## **Appendix D**

Government agency submissions

**Table D TIDC's response to government agency submissions received during the exhibition period**

**Figure 4-1b** Vegetation communities and threatened species within the study area

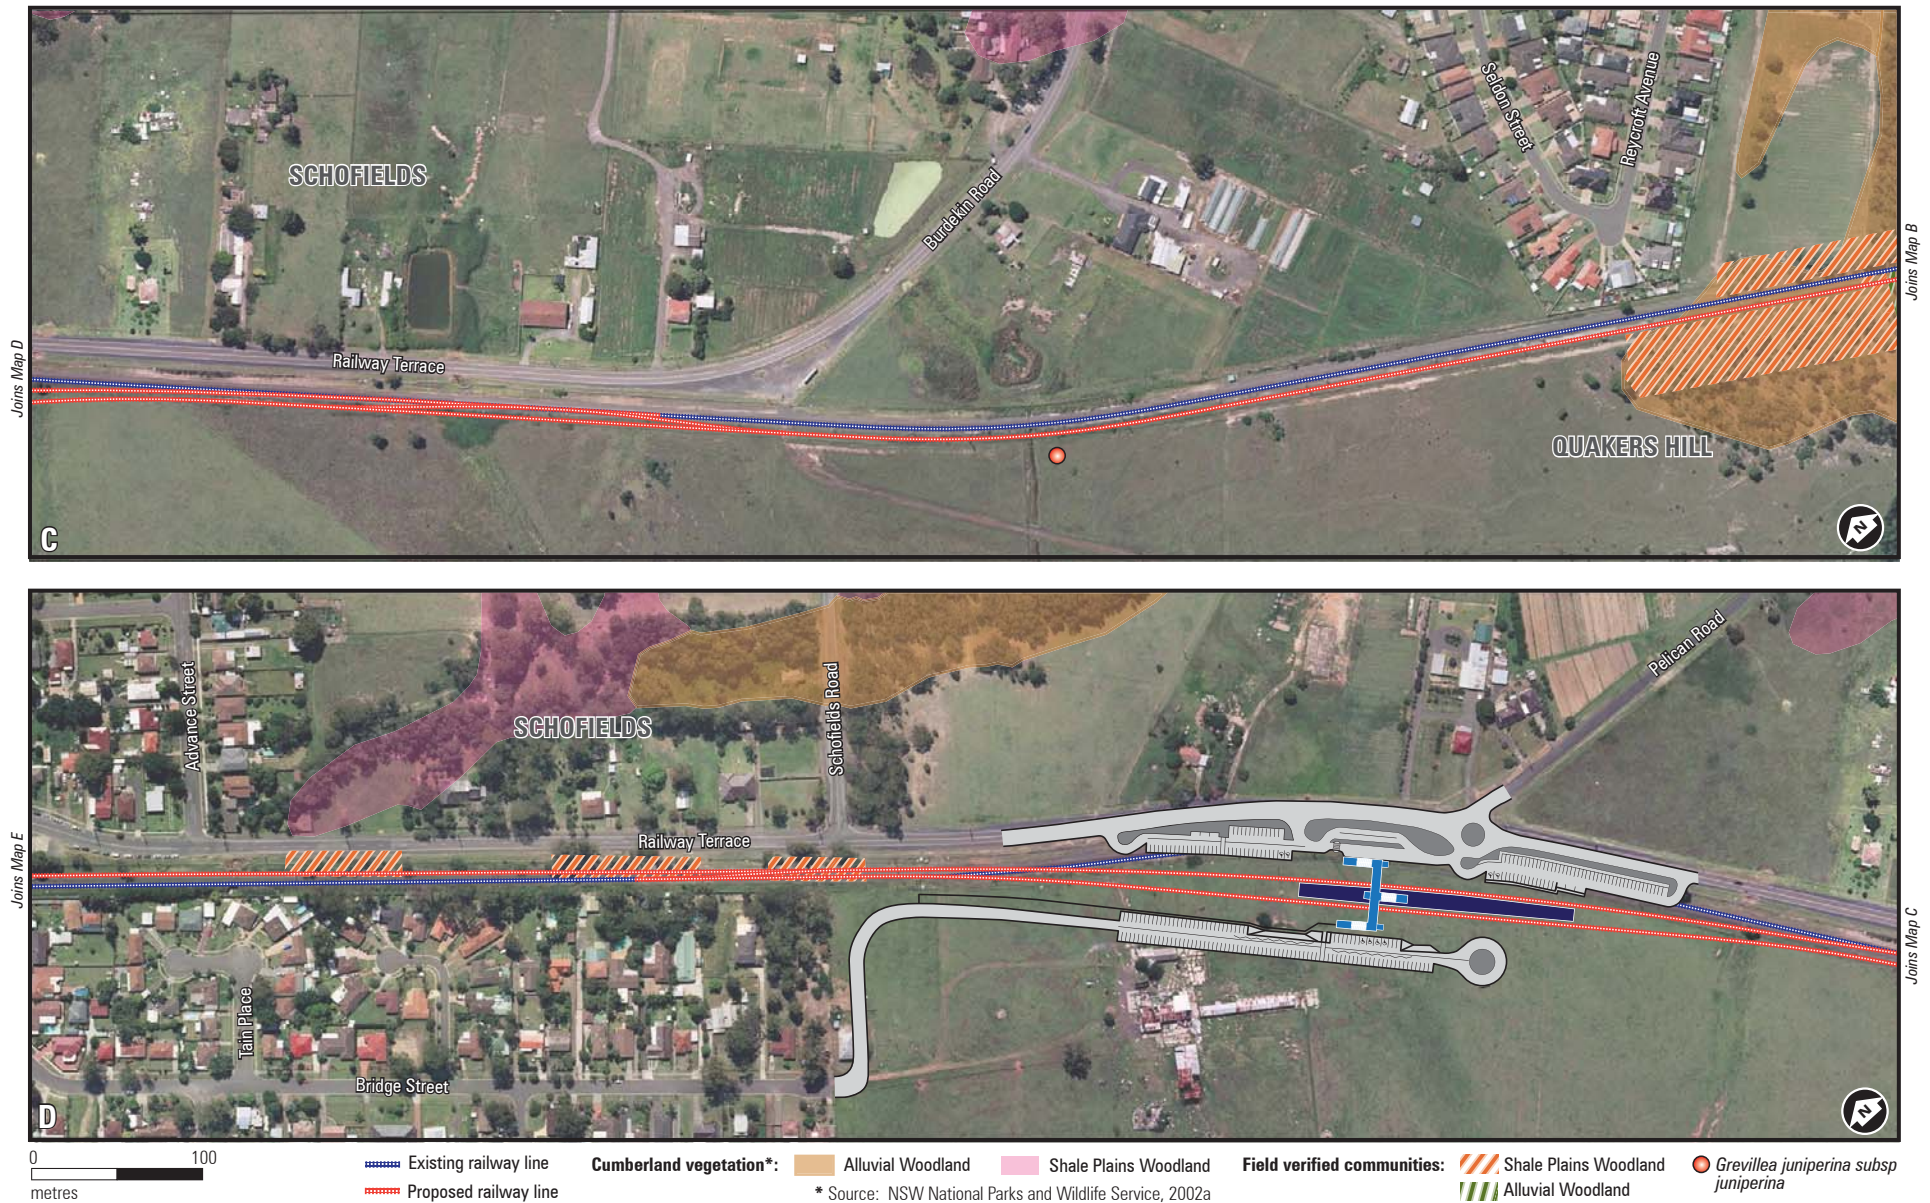
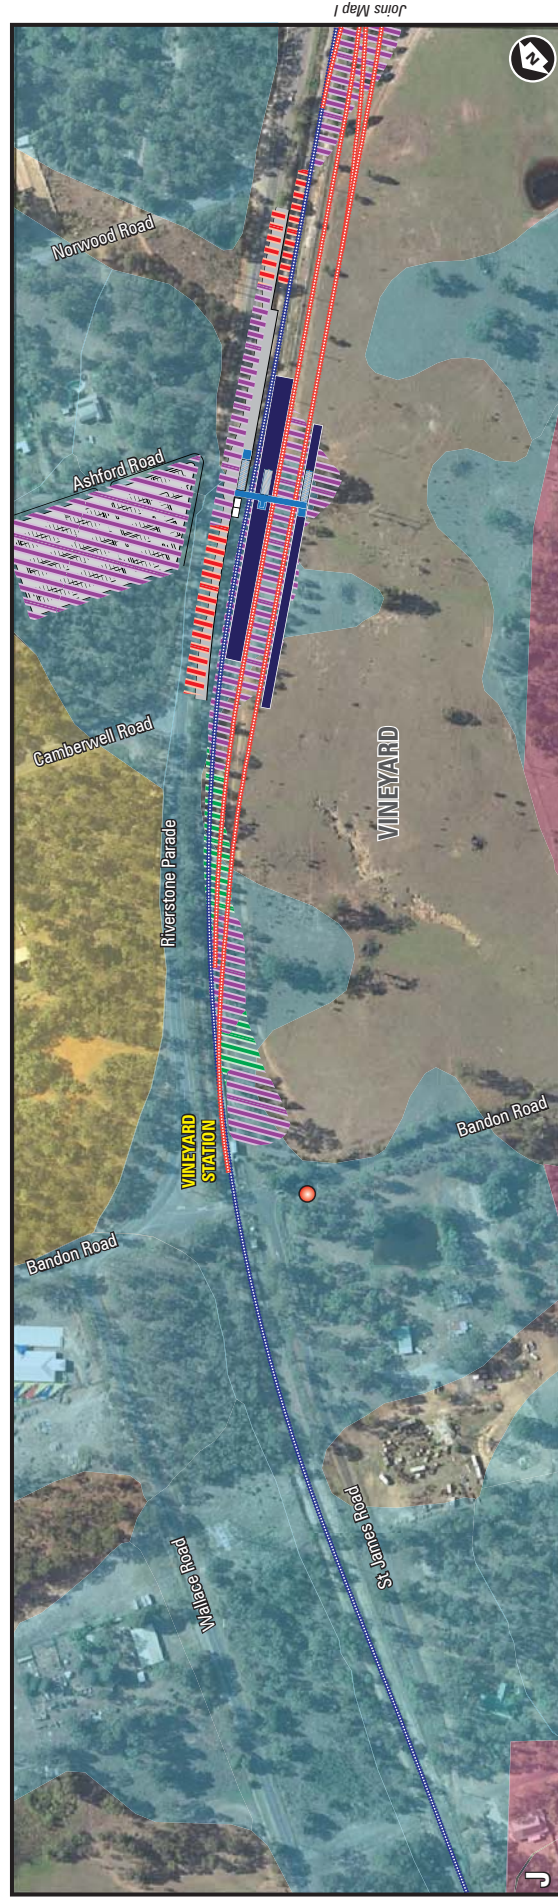
DECC	125	<p>Figure 4-1 of the Biodiversity Technical Paper still does not include EECs mapped as polygon class TXU in the <i>Native Vegetation of the Cumberland Plain, Western Sydney</i> (NPWS 2002). This figure should include this category for consistency.</p>	<p>Noted. Refer Figure 4-5 and Section 4.2.8 of the report.</p>
DECC	126	<p><i>Additional fauna surveys</i></p> <p>No details are included in the environmental assessment on the methods or effort applied in the fauna survey (except for the Cumberland Land Snail). The Department assumes that a number of species that are listed as likely to occur (e.g. bats and owls) were not surveyed. If it is not possible to do additional surveys, then the assessment must assume that all the likely species are present and be carried out on this basis. It appears the assessments were done on this basis, however the assessment does not clearly state this.</p>	<p>Surveys of the rail corridor were undertaken on 19 September 2007. Surveys on private properties were undertaken on the following dates:</p> <ul style="list-style-type: none"> <li>6 February 2008</li> <li>8 April 2008</li> <li>7 May 2008</li> <li>2-3 September 2008</li> <li>11 March 2009.</li> </ul> <p>The surveys assessed the extent and condition of vegetation communities and flora and fauna habitat.</p> <p>Survey effort and design was based on the Department of Environment and Climate Change <i>Impact Assessment Guidelines</i> (Department of Environment and Climate Change 2007c) and species specific guidelines (e.g. National Parks and Wildlife Service 2000).</p> <p>With the exception of the Cumberland Land Snail, additional targeted surveys were not completed for other fauna. As stated in 3.6.1 of the Environmental Assessment, 'where the survey was undertaken outside the optimal time for detecting some species, a precautionary approach was taken that involved the assumption that species were present if suitable habitat was identified.'</p> <p>Additionally, the tests for significance completed for Threatened ecological communities, populations and species that were either:</p> <ul style="list-style-type: none"> <li>recorded in the study area, or</li> </ul>
